DEVELOPMENT REVIEW BOARD
SUPPLEMENTAL SUBMITTAL

PROJECT NO. PR-2020-004708

Application No. SI-2020-001411

Explore Academy

C1 SITE SIGNS
1/2" = 1'-0"

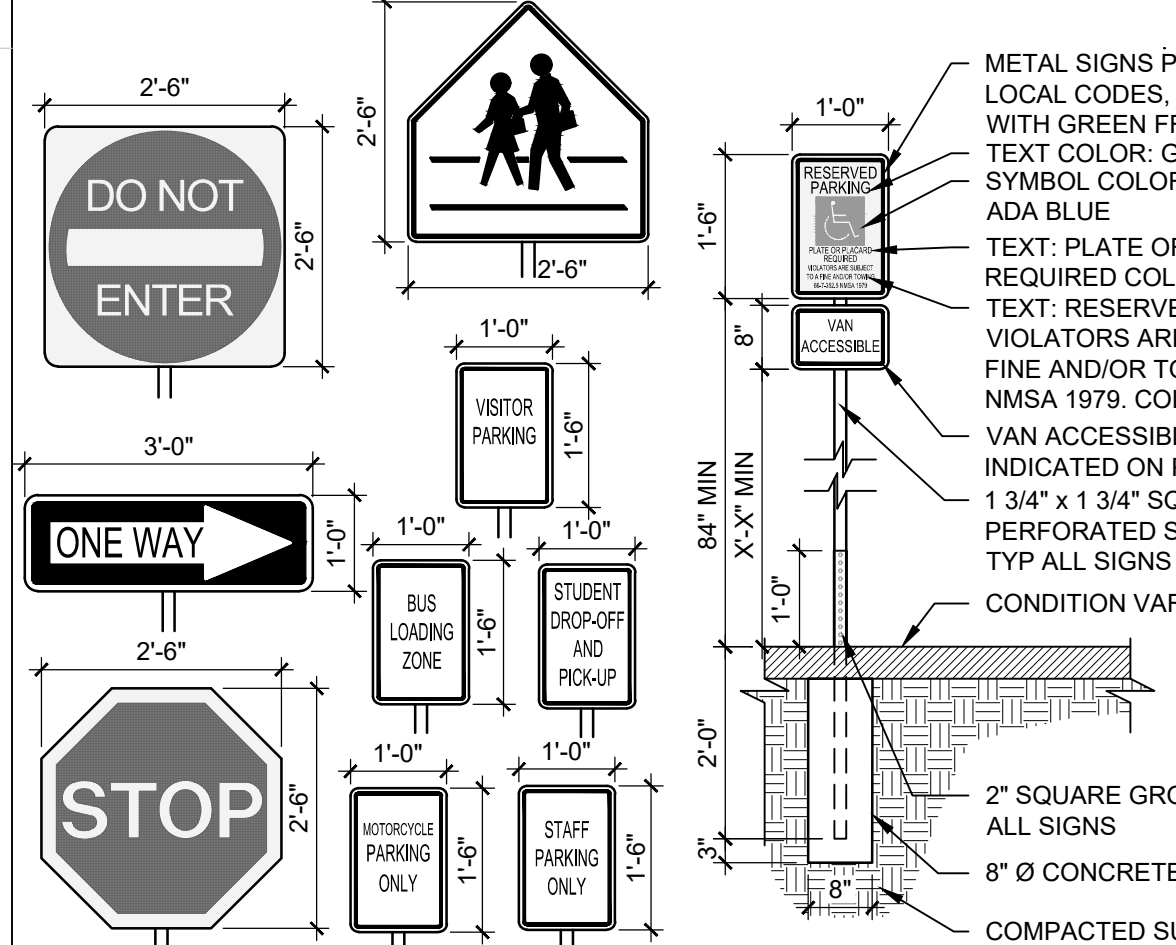
3. Include signage for bus drop-offs and any parent or employee parking. Sign details shall be included on the detail sheet.
See revised SDP1.1 and SDP1.2.
